RE: STATE INFRASTRUCTURE APPLICATION NO. SSI-9487 INLAND RAIL – NARROMINE TO NARRABRI

Thank you for the opportunity to provide a submission in relation to the Environmental Impact Statement (EIS) for the proposed Narromine to Narrabri (N2N) section of the ARTC Inland Rail Project that has been lodged with the NSW government under State Significant Infrastructure Application No SSI-9487.

Figure B3.1 **Existing flooding extents**
- one per cent AEP event (map 1)

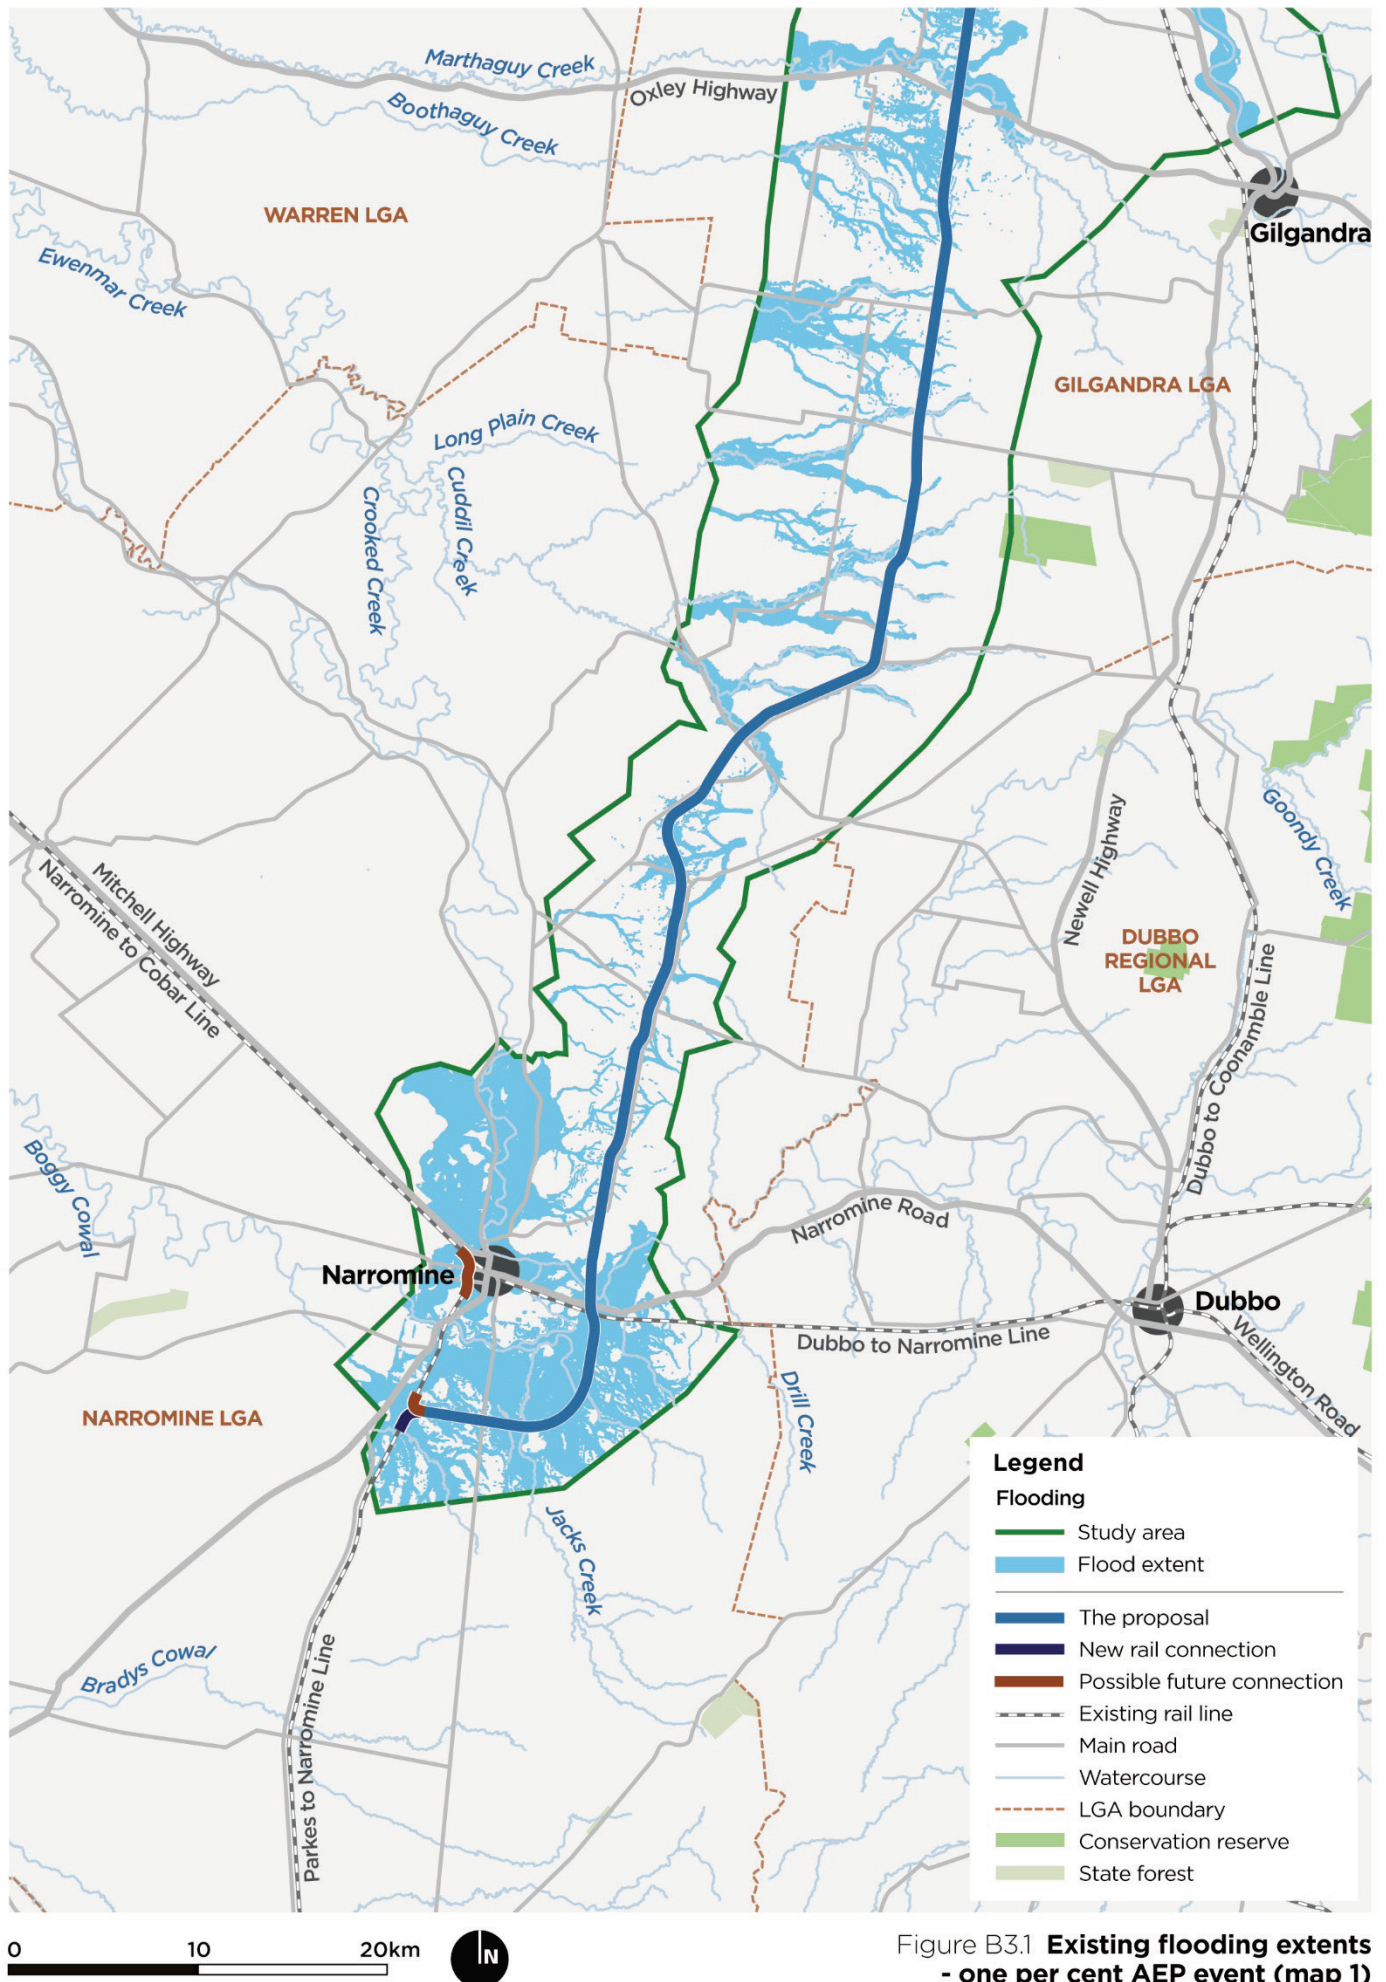
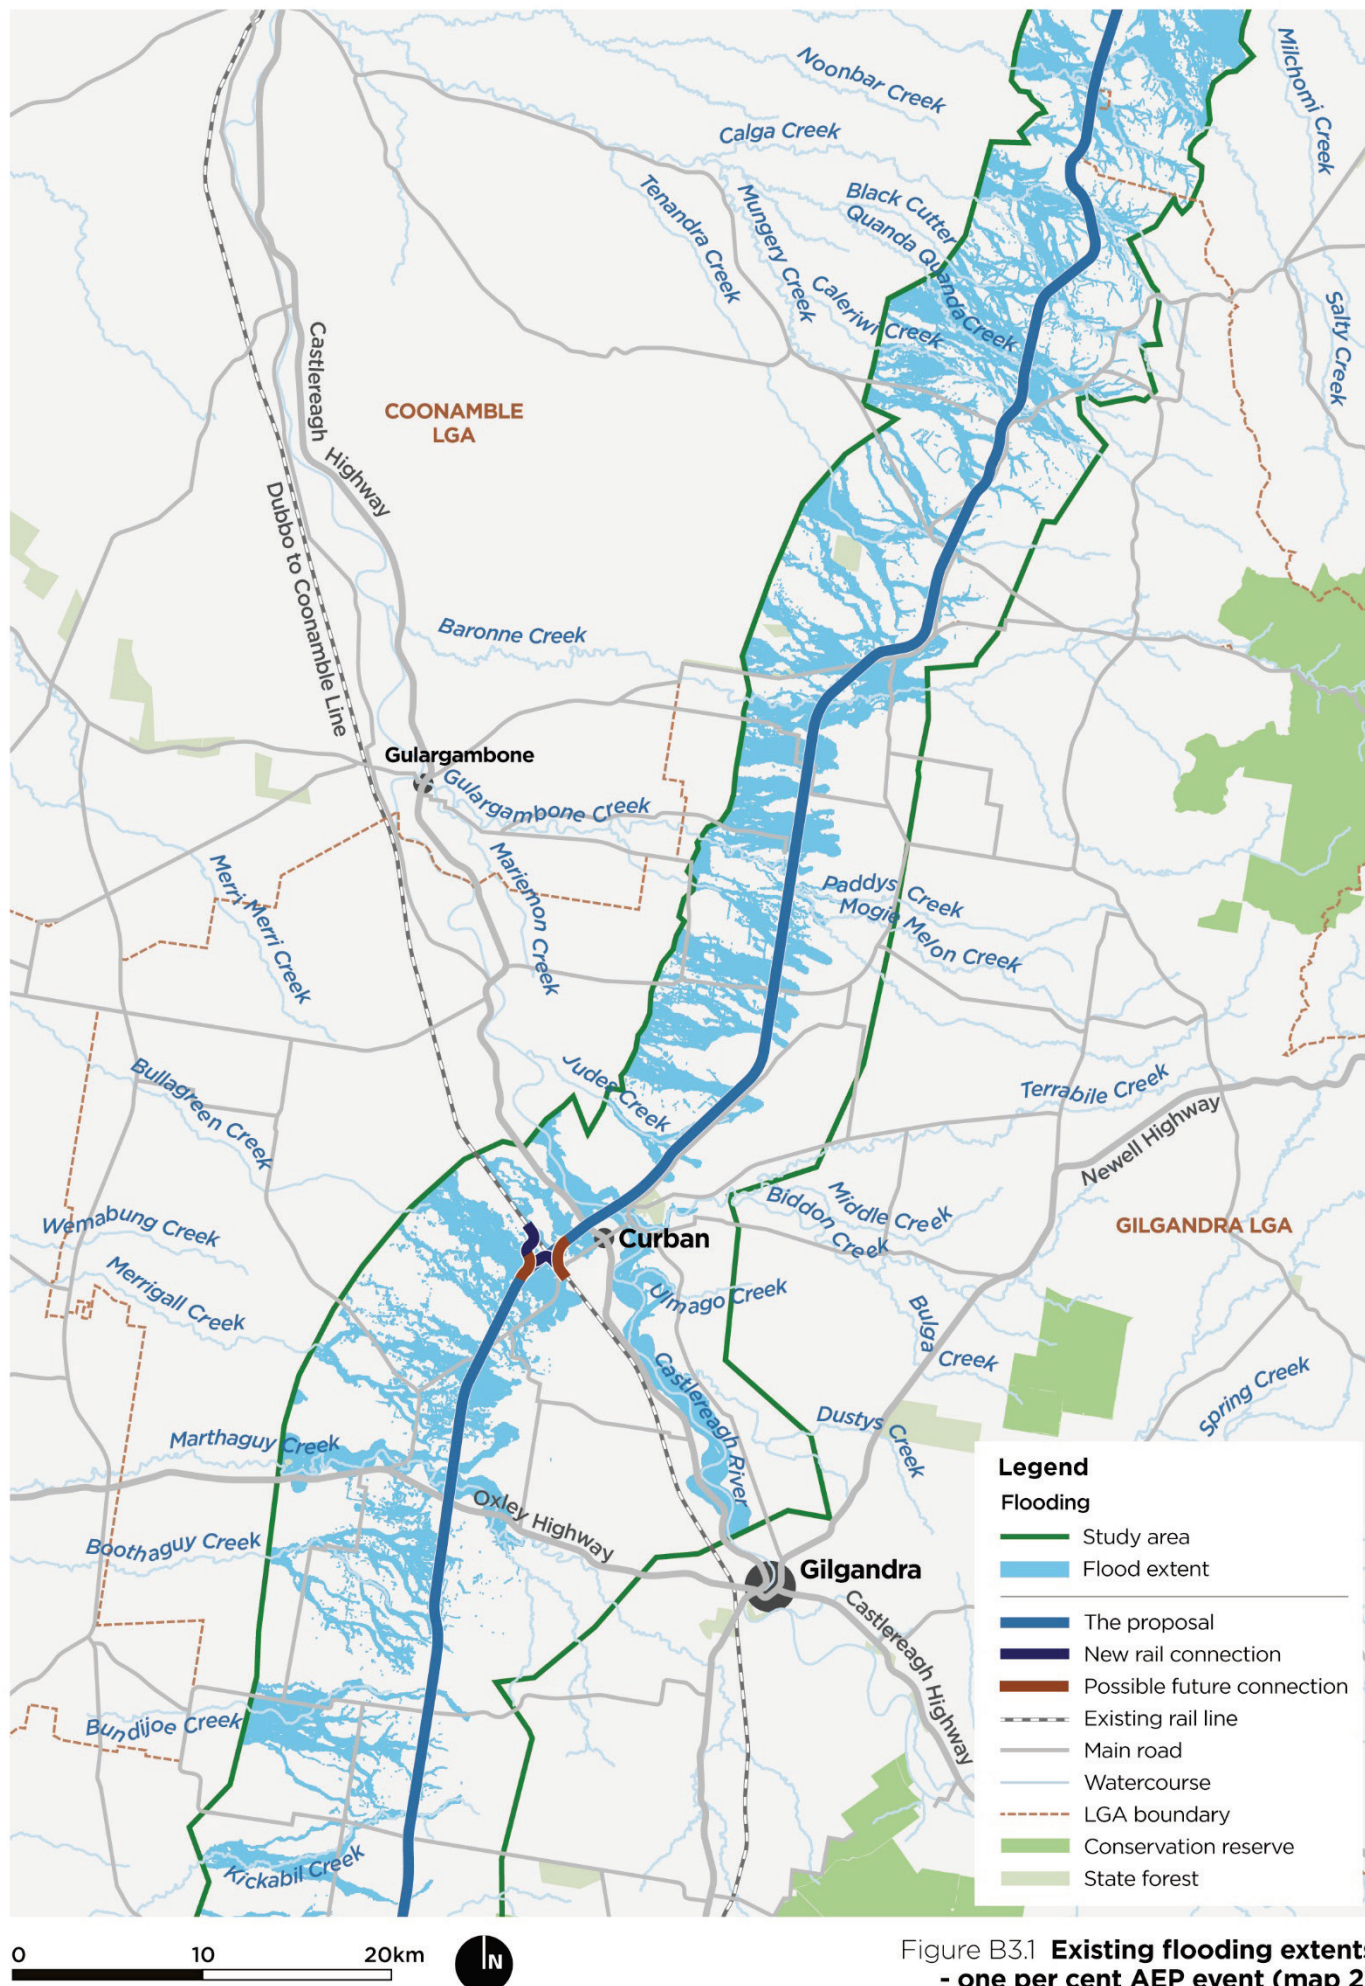
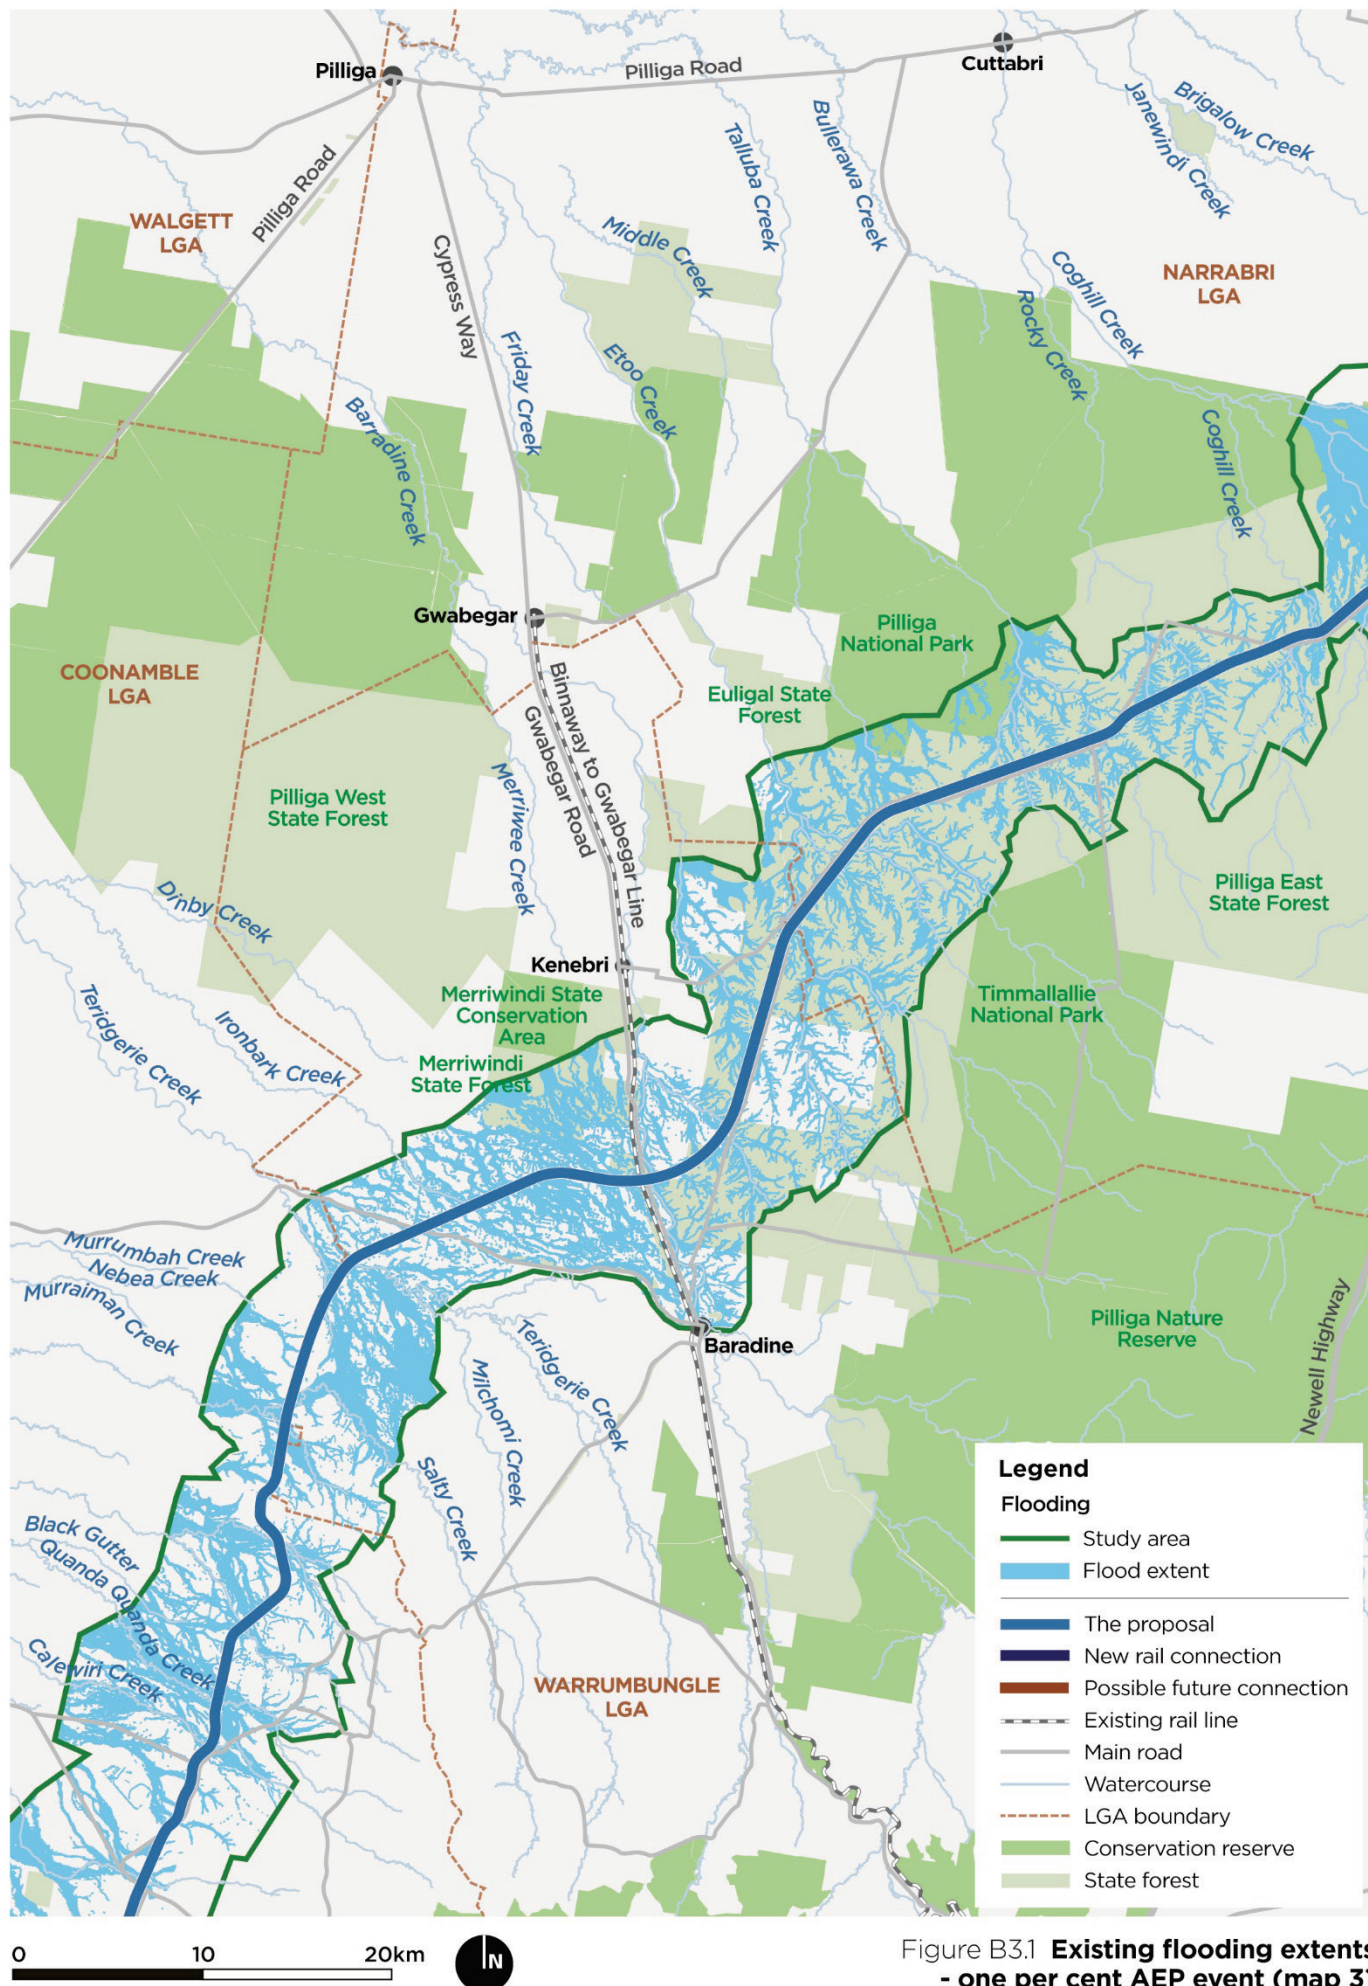
The proposed inland railway crosses several creeks and waterways in the Coonamble Shire, including the Teridgerie Creek. The EIS advises the concentration of overland flows under bridges and through longitudinal drainage and culverts could increase flow velocities and result in scour at outlets and worsening of existing erosional processes within watercourses if scour protection is not provided.

Coonamble Shire Council is concerned about the potential for flooding and drainage impacts on farming properties, dams, roads and natural ecosystems, both upstream and downstream of the proposed railway. The introduction of the new rail infrastructure will change the flooding regime, with the potential to affect surface water flows across floodplains and other areas in relative close proximity to the Warrumbungles (perceived to be flat but with enough of a gradient to result in substantial drainage of storm water towards the west and with the potential to cause significant damage).

Council recommends detailed modelling of the hydrological impacts along the railway corridor as part of the assessment of the SSI Application, to determine site specific downstream impacts of flows from proposed culverts on primary production land, dams, roads, environmentally sensitive land, heritage sites and the like.
